# CITY OF ALBUQUERQUE

May 15, 2019

**Re: Office/Warehouse Shell**  
**7410 Washington St. NE**  
**Traffic Circulation Layout**  
Engineer's/Architect's Stamp **4-22-19** (D17D03AA)

TCL MOTORCYCLE PARKING SIGN

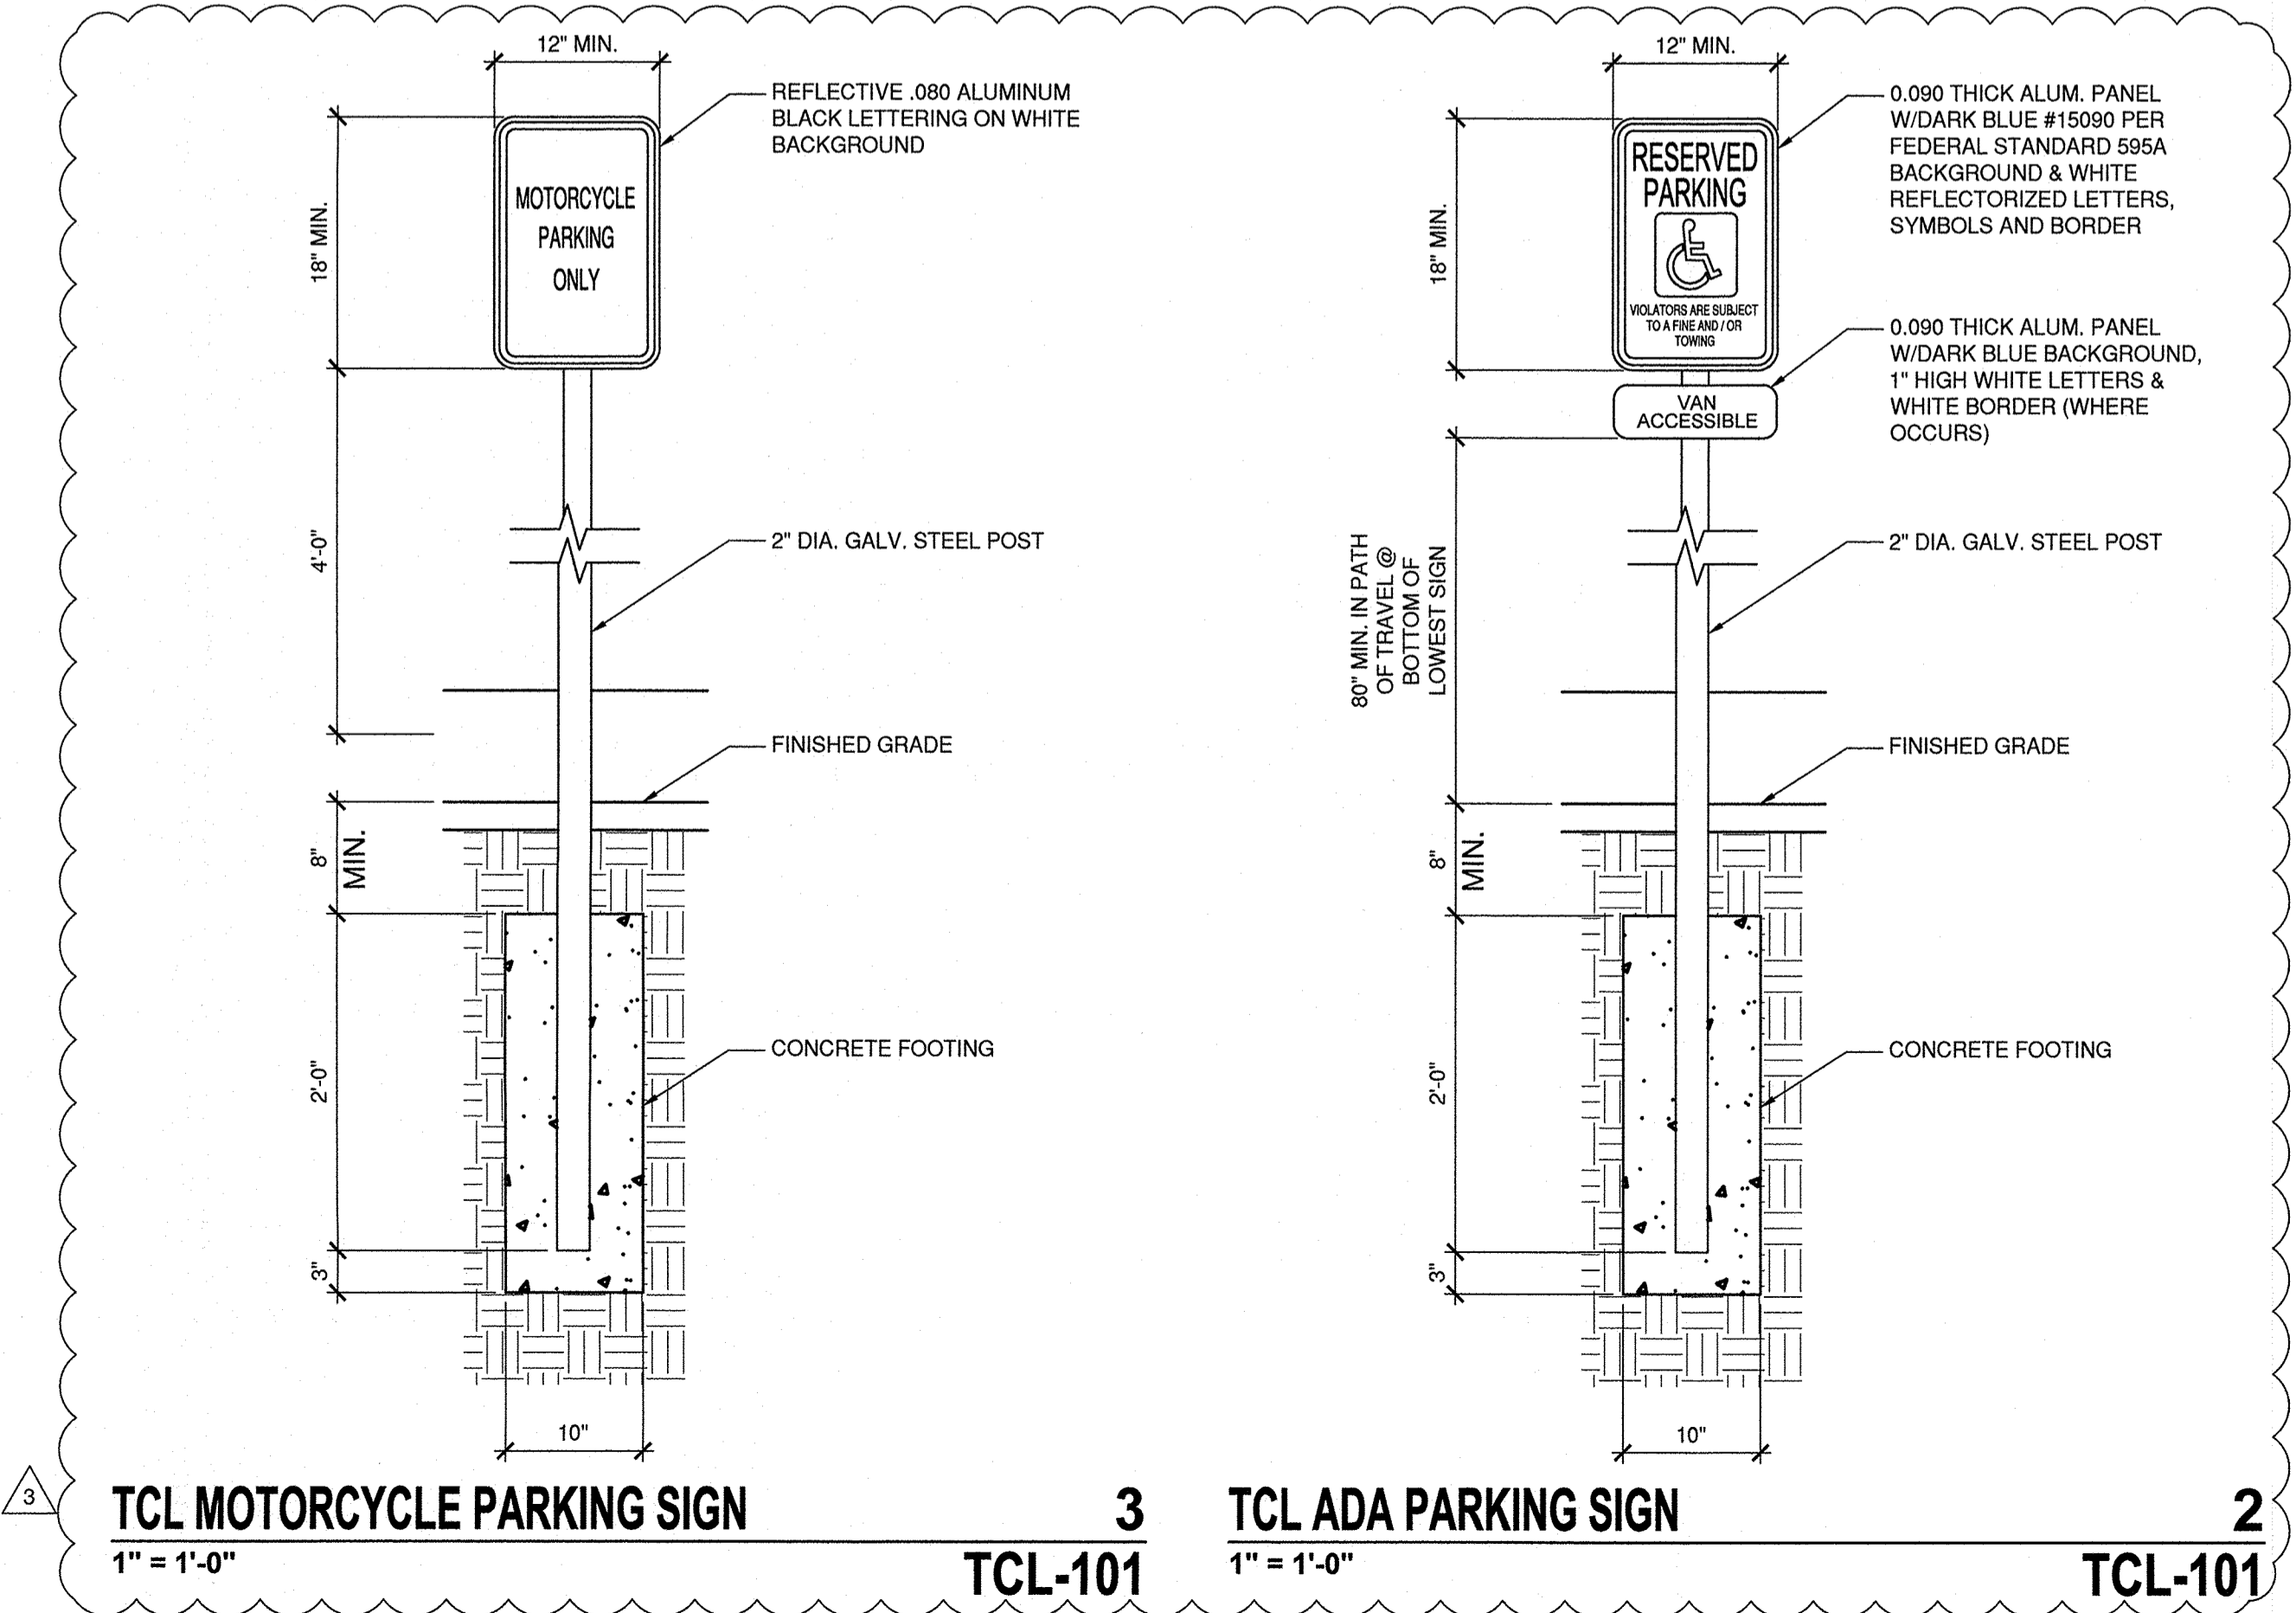
1. The ADA accessible parking sign must have the required language per 66-7-352.4C NMSA 1978 **"Violators Are Subject to a Fine and/or Towing."** Please call out detail and location of HC signs. **Please show the detail of the sign on the TCL.**
2. Motorcycle parking spaces shall be designated by its own conspicuously posted upright sign, either free-standing or wall mounted per the zoning code. **Please show the detail of the sign on the TCL.**
3. **provide a copy of refuse approval.**
4. Please include one copies of the traffic circulation layout at the next submittal.
